Comments on the Applicant's D5 Submissions

This document sets out the comments by Cambridgeshire County Council (**CCC**) and Fenland District Council (**FDC**) (together, **the Councils**) on the Applicant's Deadline 5 (**D5**) submissions. The tables below set out the document in question that the Councils are commenting on, together with the relevant paragraph or reference number.

2.4 Access and Rights of Way Plan - Revision 5.0 [REP5-004]

MEDWORTH CHP LIMITED
MEDWORTH ENERGY FROM WASTE COMBINED HEAT AND POWER FACILITY
CHANGE APPLICATION
ACCESS AND PUBLIC RIGHTS OF WAY
APFP REGULATIONS: 5(2)(k)
SHEET 1 OF 4

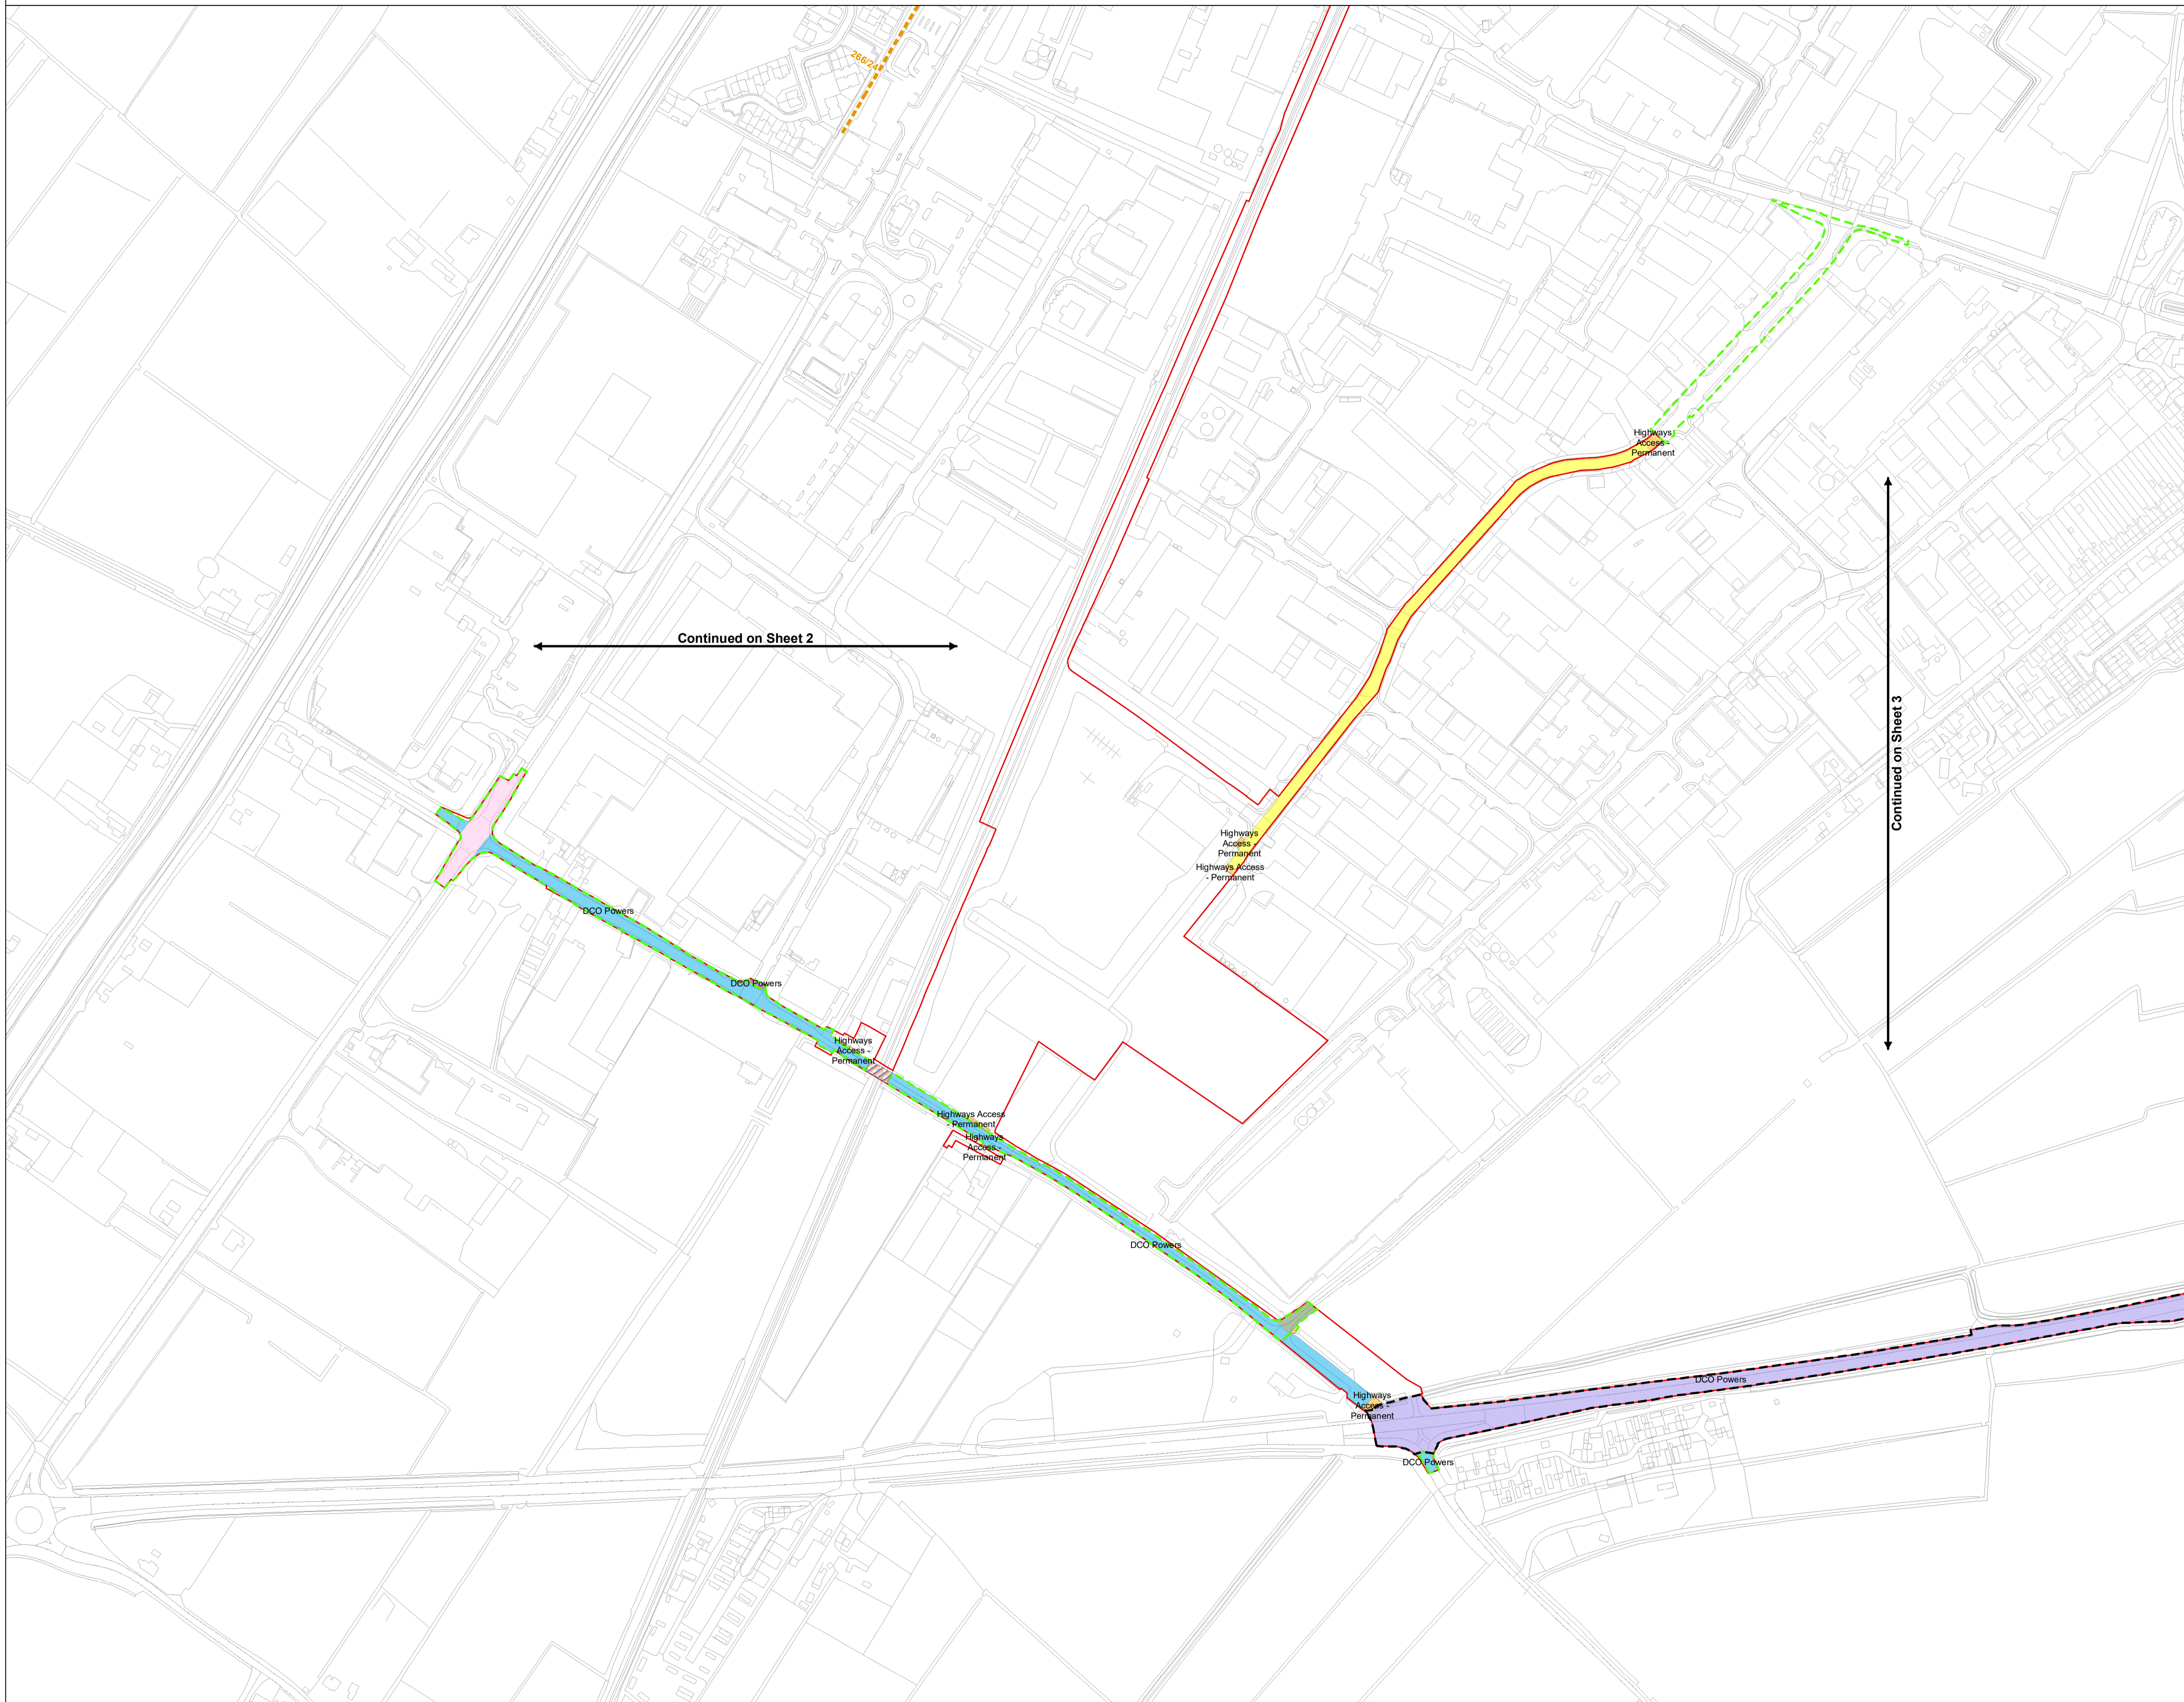
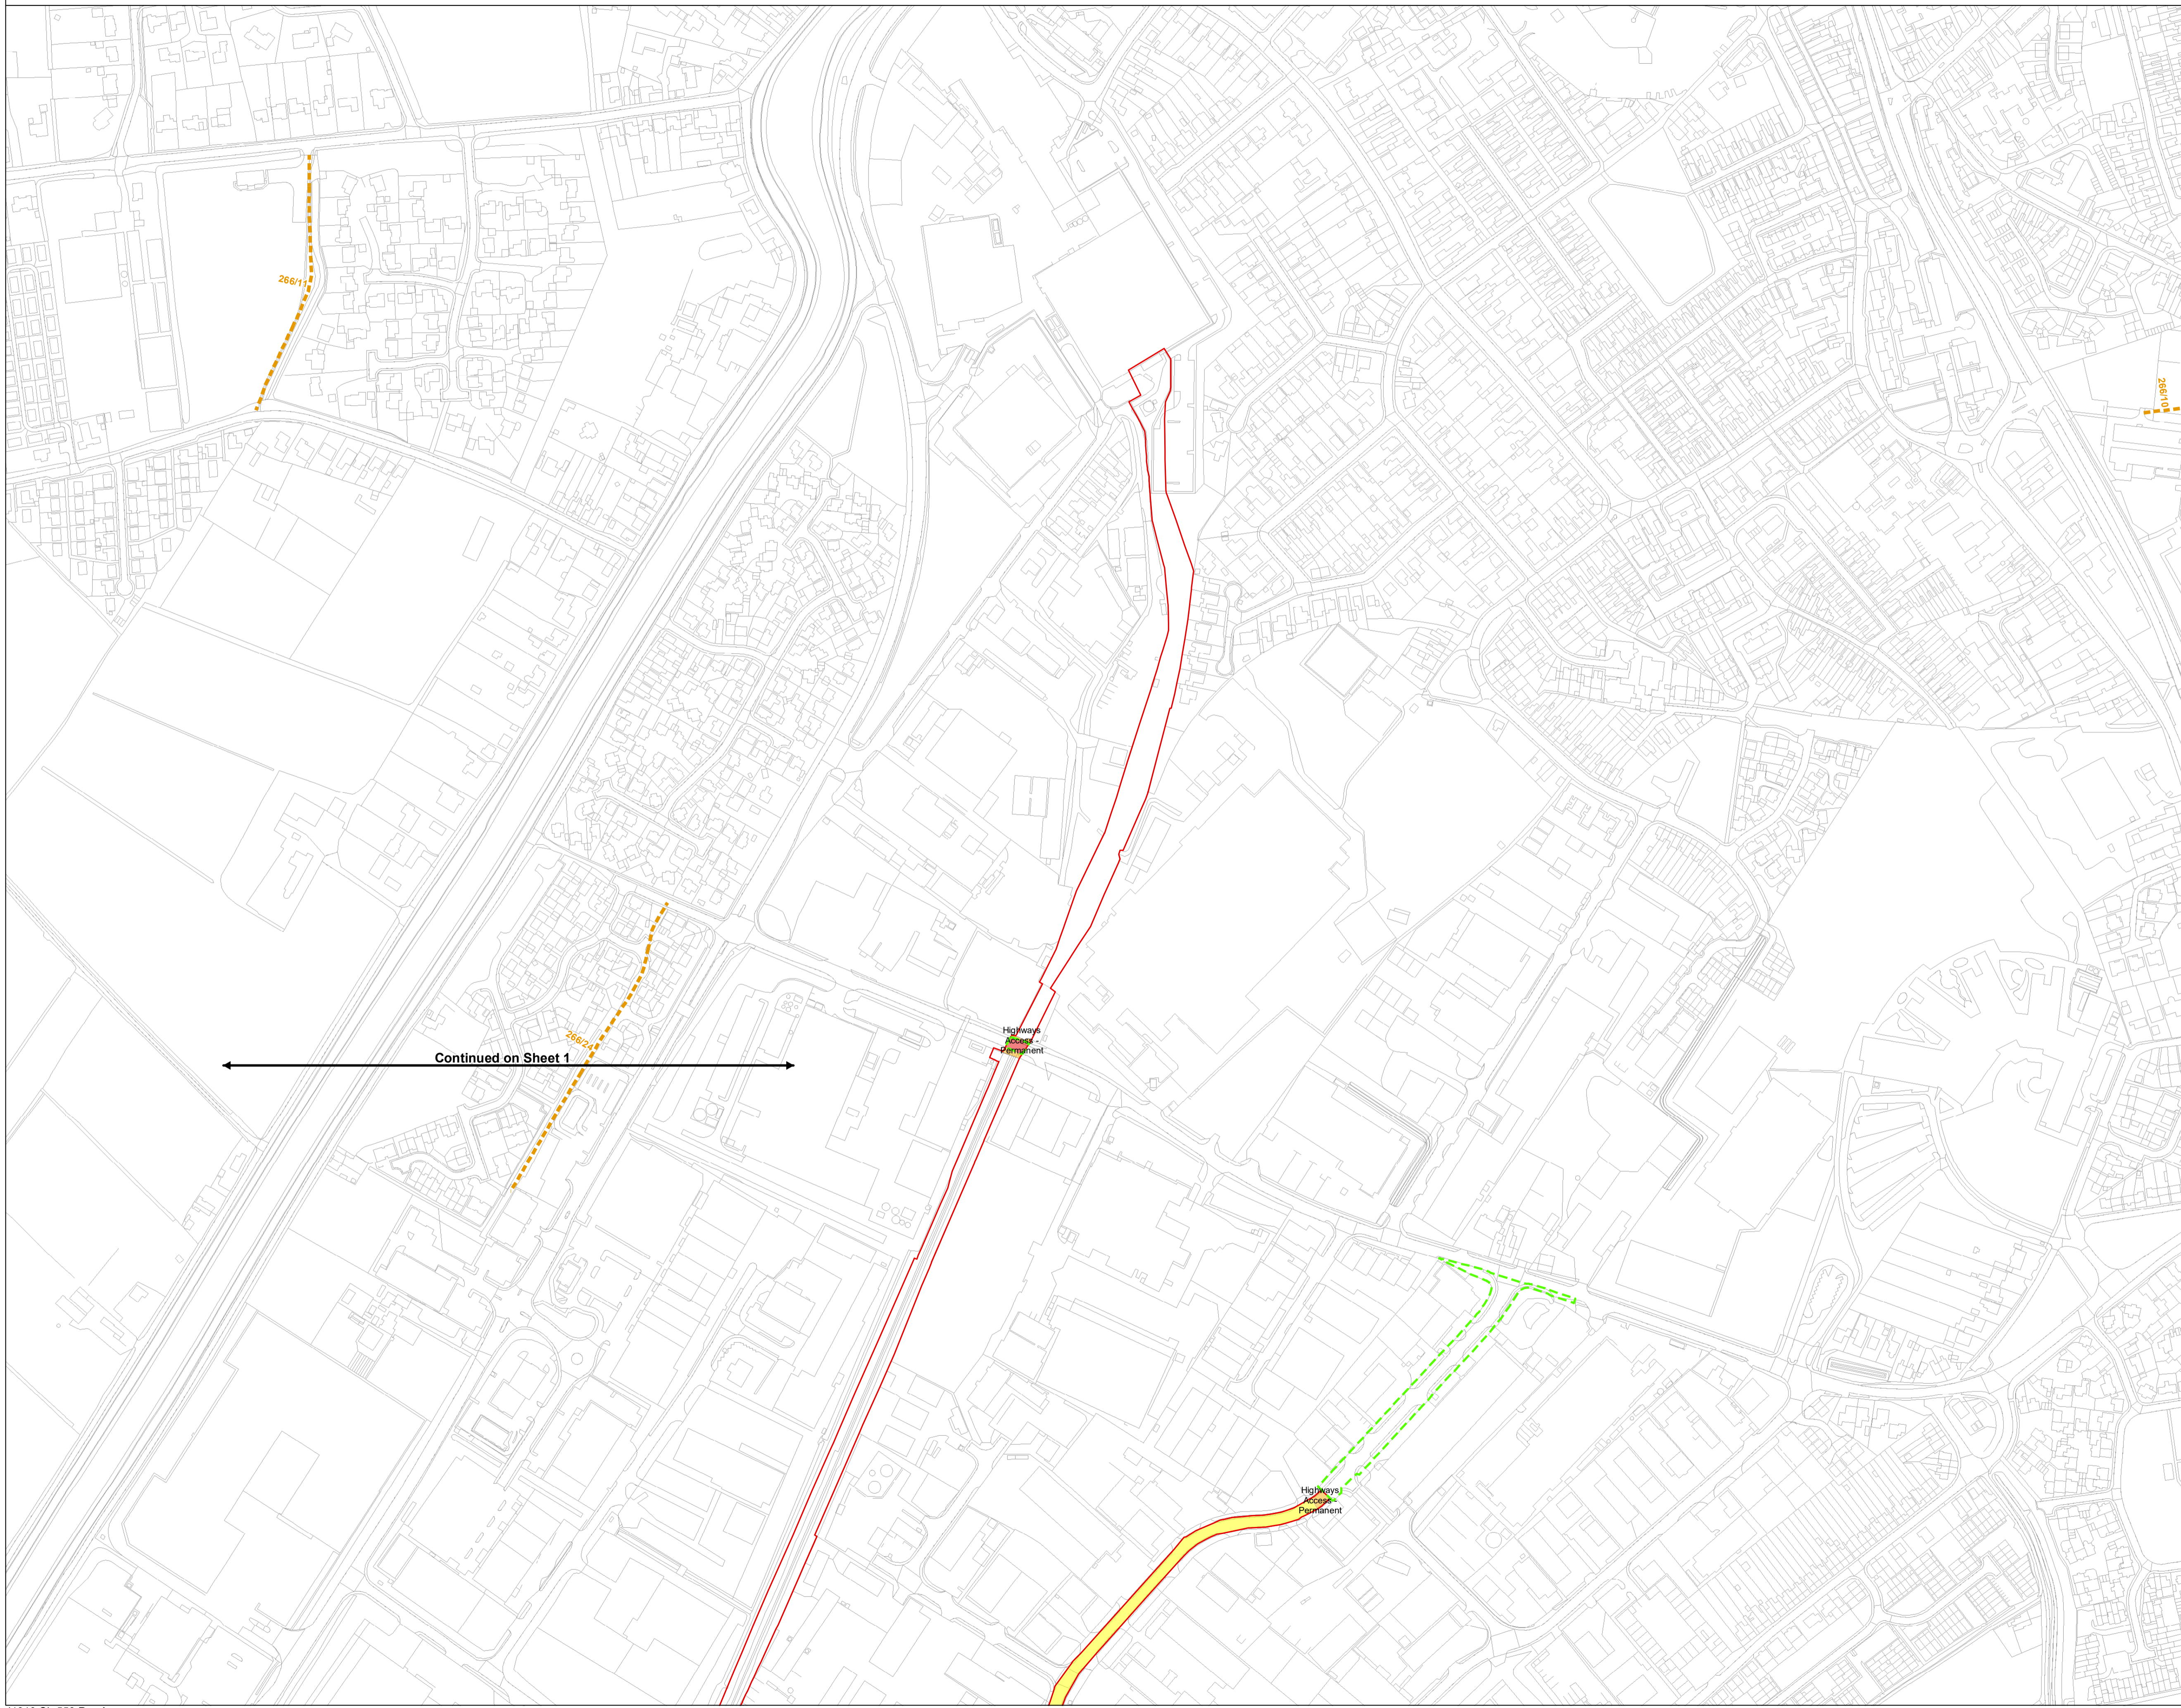
Topic	Paragraph Number	Councils' Comment
Boundaries of local highways	All plans	This version of the Access and ROW Plans appears to have been superseded by the change application submitted by the Applicant, which seeks to broaden the DCO boundary at the junctions of New Bridge Lane with both Cromwell Road and Salter's Way. Accordingly, the highway boundaries within the Order Limits would, if the Change Application is accepted, require to be updated to reflect the larger area of highway that is required to work within.
Boundaries of local highways	Plan 1 of 4	Following the discovery by CCC of new information about the highway boundary at the junction of Cromwell Road and New Bridge Lane, CCC and the Applicant have been in liaison about the effect this information has on the highway extent that is available for the Applicant to work within. This revised extent is reflected in the Applicant's Change Application documents, but is not shown on this version of the Access and ROW Plans.
